**ANGEL PLACE
LEVEL 8, 123 PITT STREET
SYDNEY NSW 2000**

AUSTRALIAN TURF CLUB NIGHT RACING – RESPONSE TO SUBMISSIONS – HISTORICAL AND ABORIGINAL ARCHAEOLOGY

Table 1 – Response to Agency Submissions

Figure 5.4 Potential Historical Archaeological Significance.

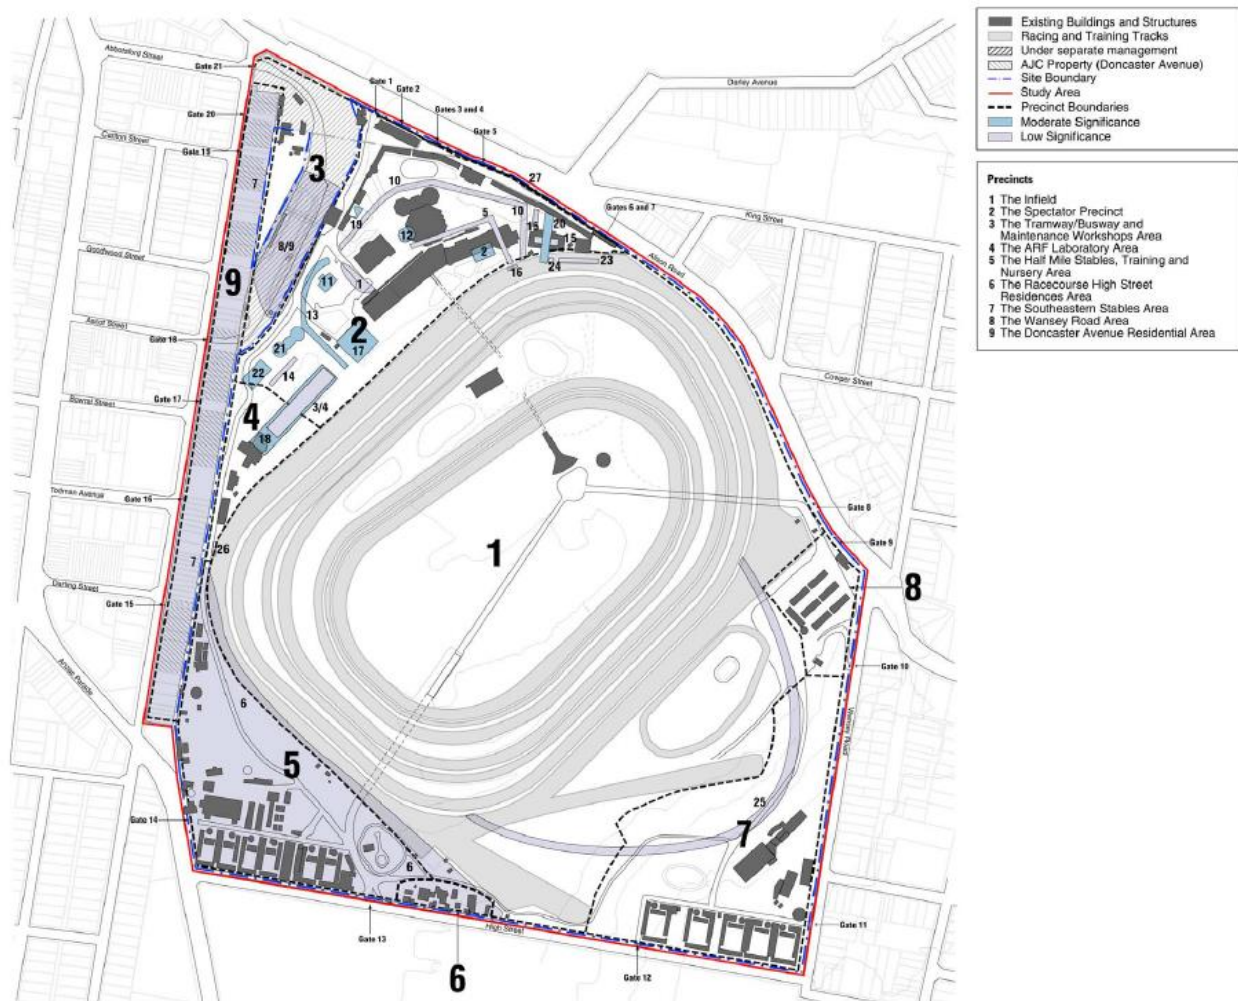
<p>The Potential Historical Archaeological Significance mapping identifies a number of sites within the Spectator Precinct and the ARF Laboratory Area, associated with previous structures, as being of Moderate significance and it is unclear whether excavation for the footings of the proposed light columns will impact on these archaeological values.</p>	<p>The addendum HAIA letter has considered the impacts of the proposed works against areas of identified potential and significance as identified by GML in 2006 and updated by Urbis in 2021. This is provided in Appendix A. the addendum HAIA has concluded the structures will not impact on the archaeological resources associated with the Spectator Precinct and ARF Laboratory area, with the 12 light columns proposed in areas outside of identified significance.</p>
<p>Heritage NSW as delegate of the Heritage Council of NSW</p>	
<p>The subject site is not listed on the State Heritage Register (SHR), nor is it in the immediate vicinity of any SHR items. Further, the site does not contain any known historical archaeological relics.</p> <p>Therefore, no further heritage comments are required. The Department does not need to refer subsequent stages of this proposal to the Heritage Council of NSW.</p>	<p>N/A</p>

37. The assessment of Aboriginal archaeology is sufficient to meet statutory requirements, and the recommendations of the Due Diligence letter should be included as consent conditions, subject to clarification of the site number which has been quoted.	An Addendum ADD has been prepared and is included in Appendix B. The recommendations have remained with minor alteration to satisfy comments from Heritage NSW, as below.
European archaeology 38. The Heritage Impact Statement prepared by Urbis includes the Potential Historical Archaeological Significance mapping from the 2006 Godden Mackay Logan Conservation and Management Plan for the site which identifies areas on the site having Moderate-Significance and Low Significance in relation to historical archaeological sensitivity. No assessment of the proposal in relation to this mapping has been provided however, and the SSD submission is deficient in this regard.	Urbis have prepared and addendum Historical Archaeological Impact Assessment (HAIA) letter, which is included in Appendix A. This letter considers the archaeological potential and significance of the subject site (in accordance with the <i>Heritage Act 1977</i> , as amended 2009). This has necessitated updates to the 2006 GML CMP grading of archaeological significance which does not meet the requirements of the legislative changes which came into effect in 2009. This assessment has considered the impacts of the proposal against the 2006 archaeological zoning plan prepared by GML for the CMP.
